Martin Nugent
01254 770884
D3/09/0791

**Planning Applications, Ribble Valley District
D3-09-0791 land at Barrow Brook, Barrow, Clitheroe**

01254 770984
Traffic and Development Engineer

2.1 Proposed Site Plan.

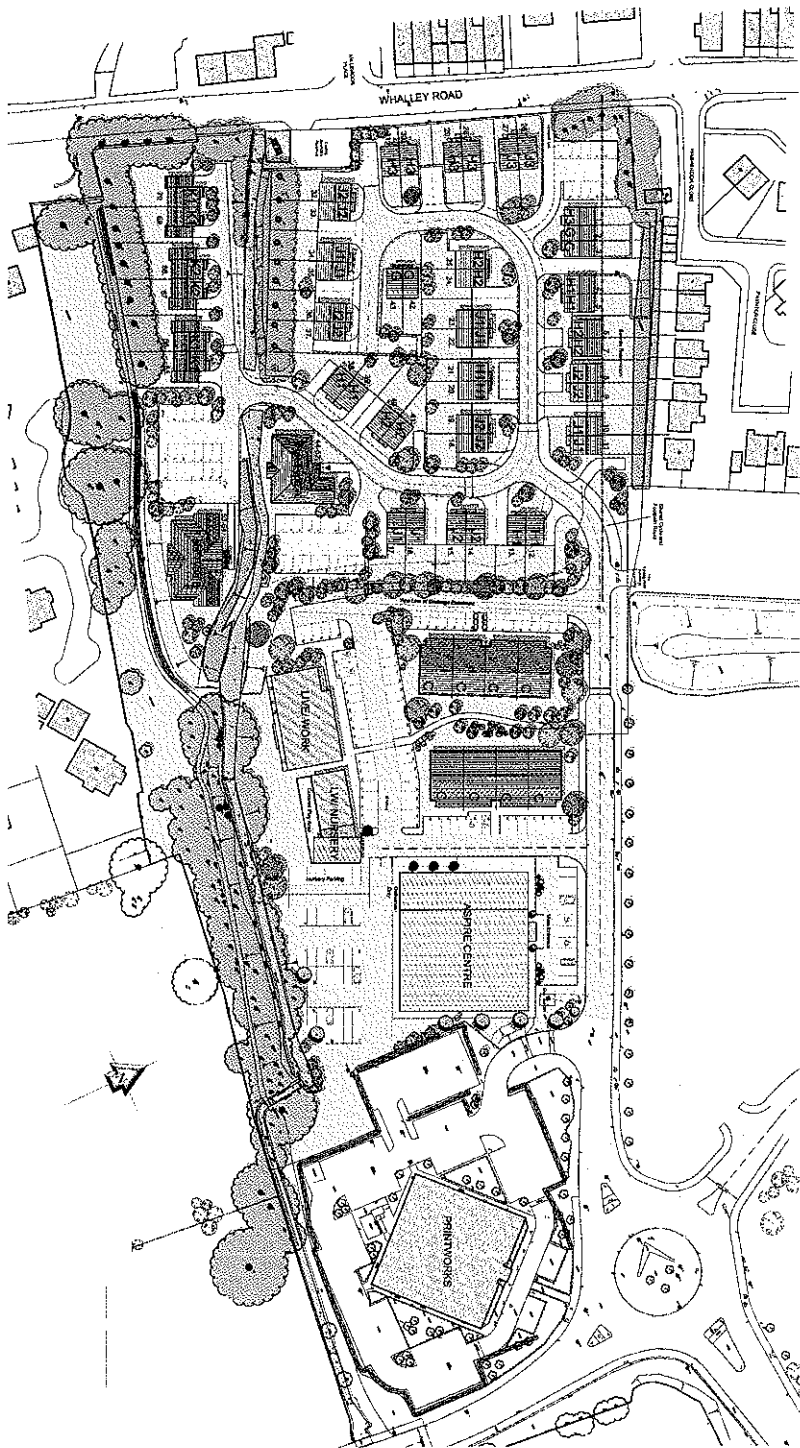
There is adequate parking provision for individual premises and residential areas, in line with the NW Partial Review Parking Standards. However, there are three locations where "double-tandem" parking is proposed. These areas are to the rear of properties 1-5 and behind 42 and 43. This is inconsistent with the design and layout of parking proposed elsewhere within the site and should be reviewed as it is unclear how it would operate successfully in this setting.
